Re: Development of 9 WME TREE CLOSE, East Preston

Ref: EP/52/18/PL

Drawing ref: LTC.PLOT7.001

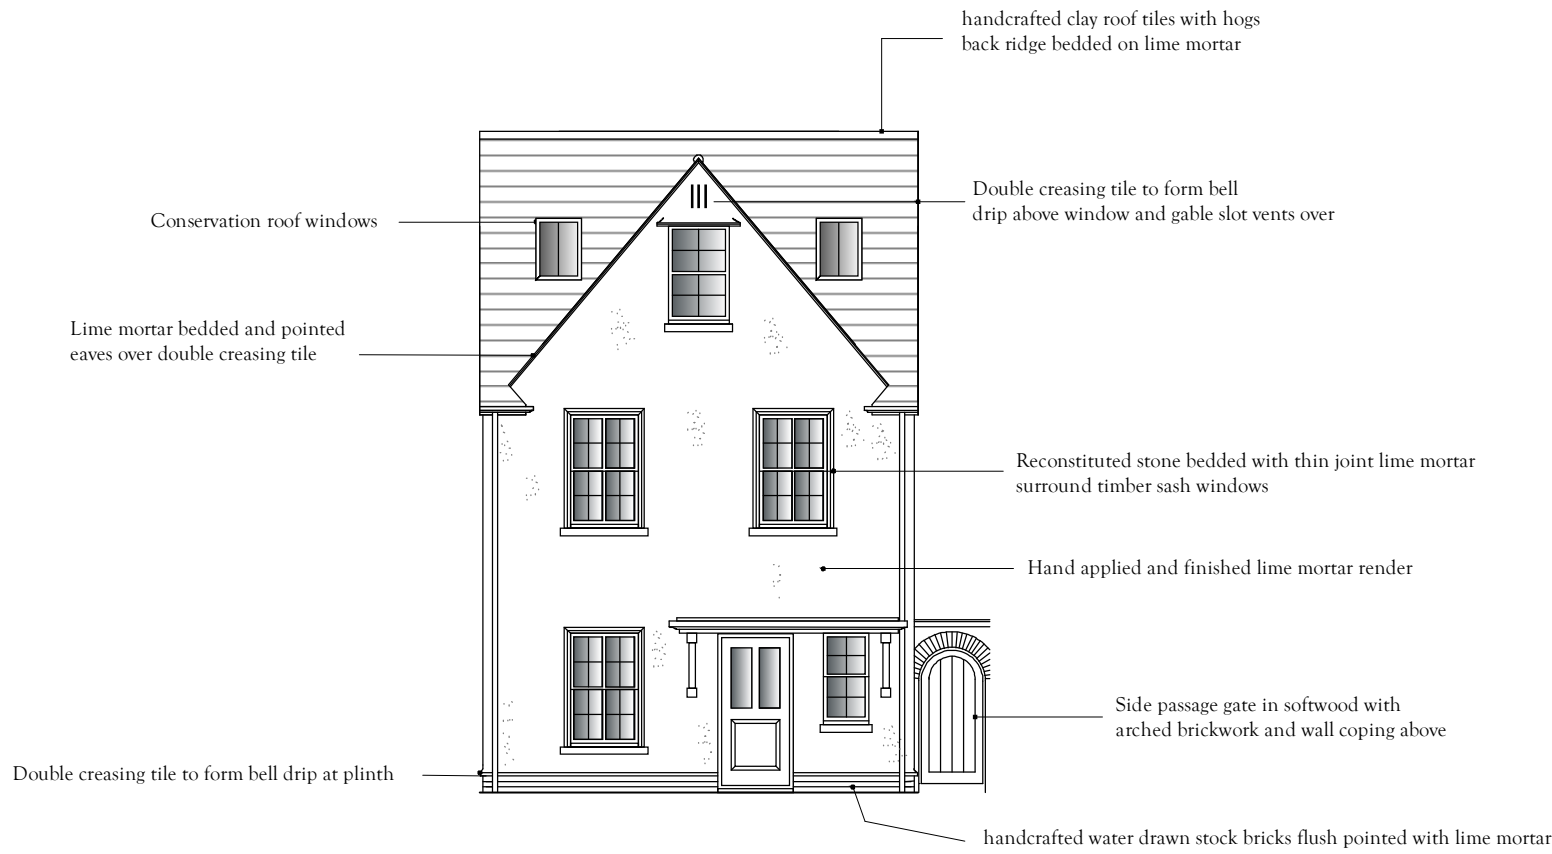
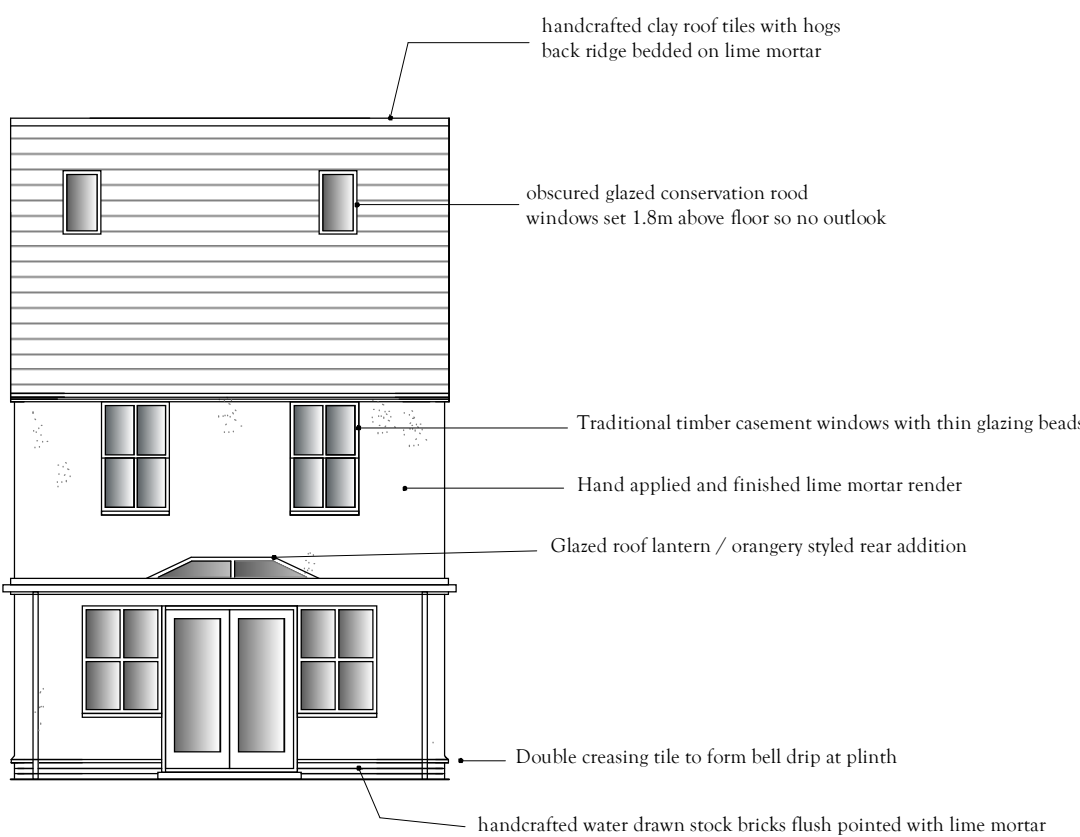
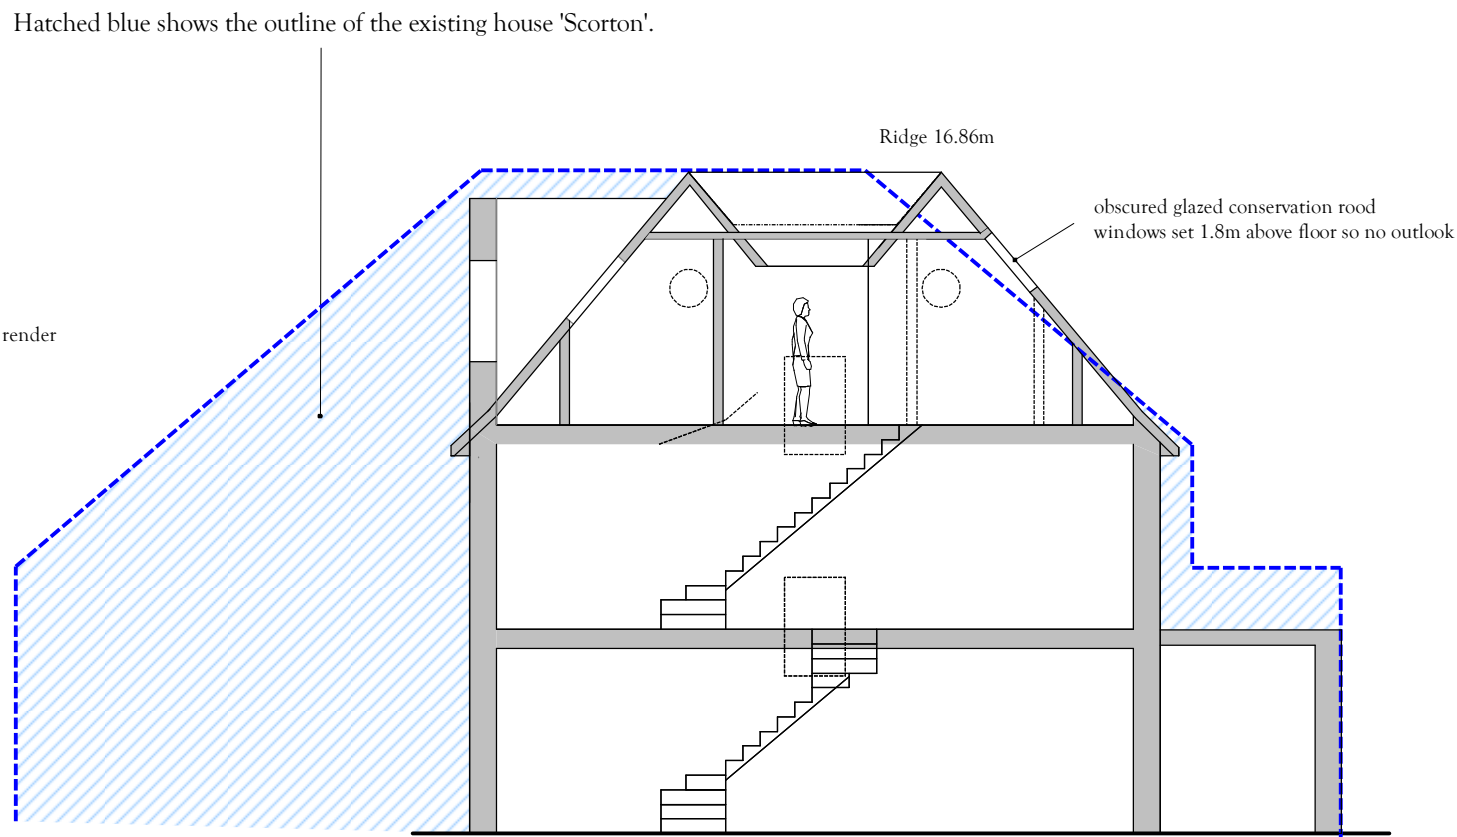
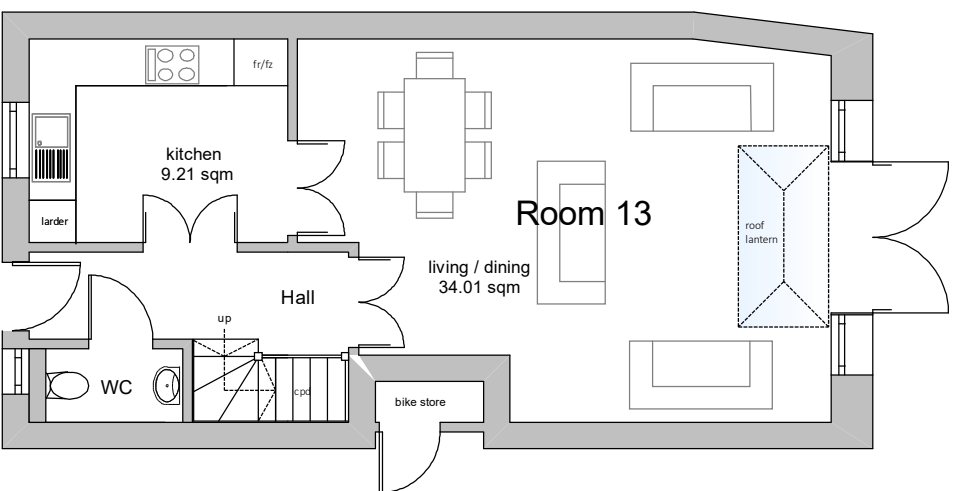
③ I see the beautiful tree at the fence-line (in the soon to be Plot 7) (which is at the bottom of my garden) is not marked on the building plan. Surely it is NOT going to be chopped down?

④ My garden is not overlooked at the moment. But I presume the new cottages are two storeys high with tall roofs. Bang goes my privacy and sunlight!!
